Recommendation Report

Application No. FP/59/12

Demolish existing garden building and replace with new garden room.

1 The Grove Bognor Regis

DRAWING
GROUND AND ROOF PLAN, & SECTION
DRAWING No. GR/01
REVISION
SCALE 1:50
PROJECT STAGE PLANNING

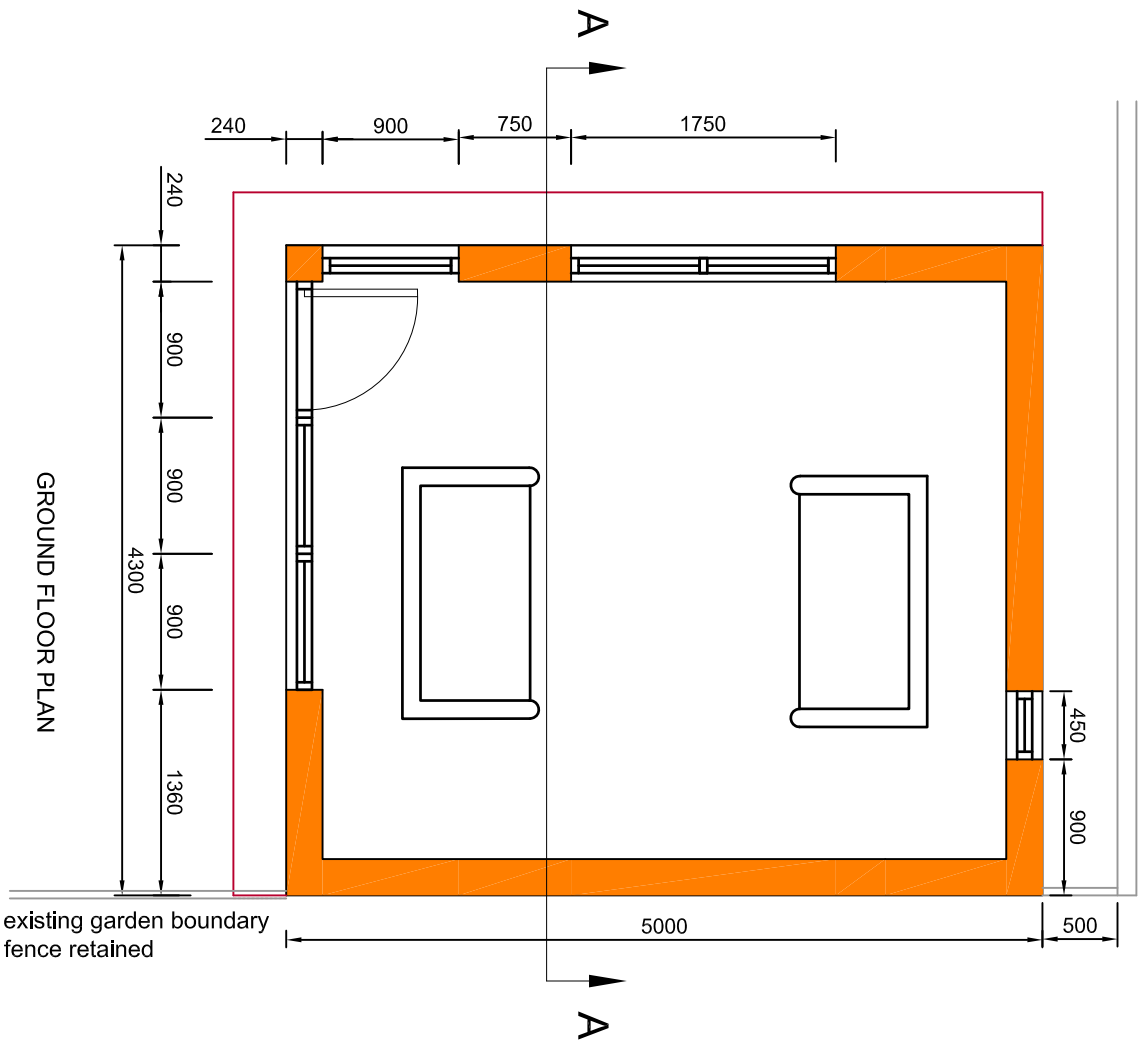
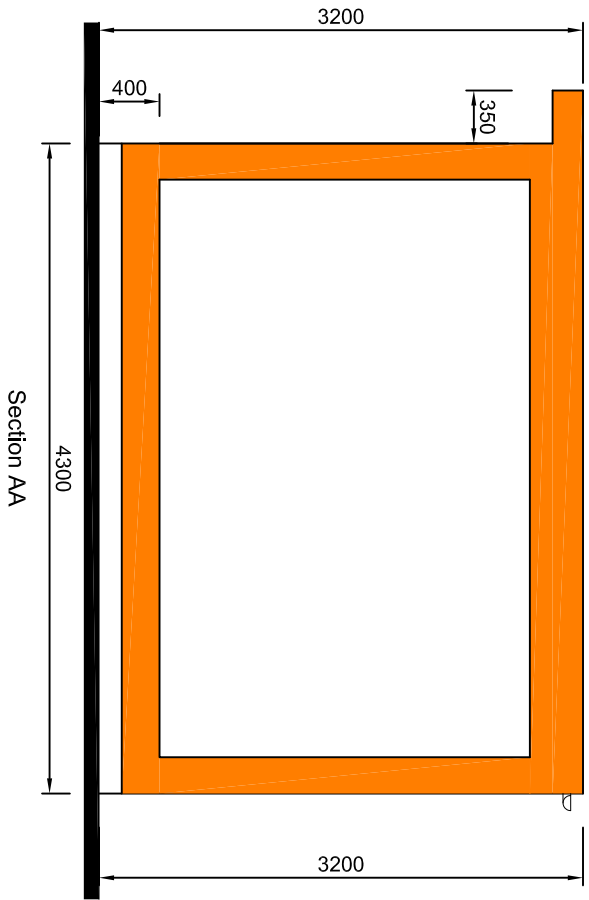
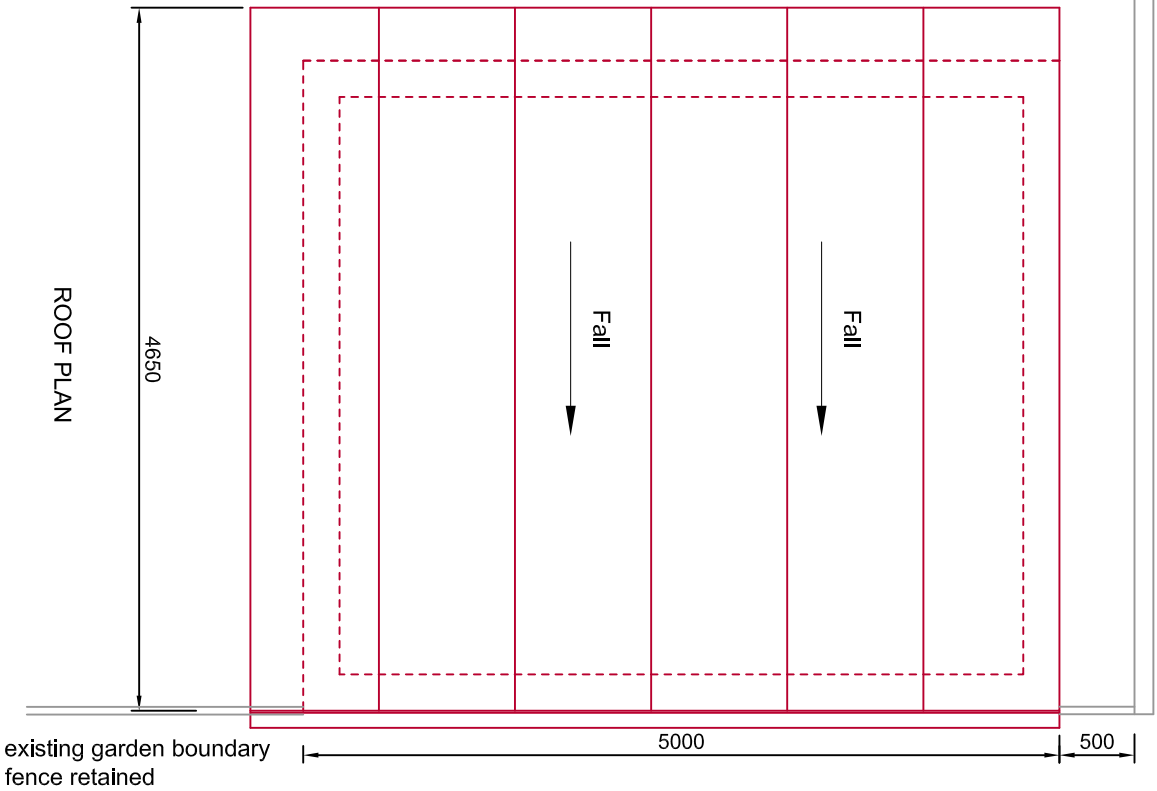
Pls reduce height of building →

Considered too high, visually intrusive
& overbearing.

With reference to our telephone conversation yesterday, I have spoken to my Manager regarding the application. It is suggested that the height of the outbuilding is reduced to reflect the height of the existing shed, given its siting close to the boundary with the neighbouring property, in order to reduce its visual prominence and overbearing impact on the neighbouring property.

On the basis of the current scheme, the application is therefore recommended for refusal on the basis of its overbearing impact on the neighbouring property, by virtue of its siting, scale and close proximity to the rear garden boundary.

If reduce to 2.5m overall height,

works may be done as permitted
development.

If the height of the outbuilding is reduced to no more than 2.5 metres within 2 metres of any boundary, the outbuilding may be erected as 'permitted development', and will therefore not require a formal planning application. You may wish to consider this option, further details of which can be viewed on the Planning Portal: <http://www.planningportal.gov.uk/permission/commonprojects/outbuildings/miniguide>
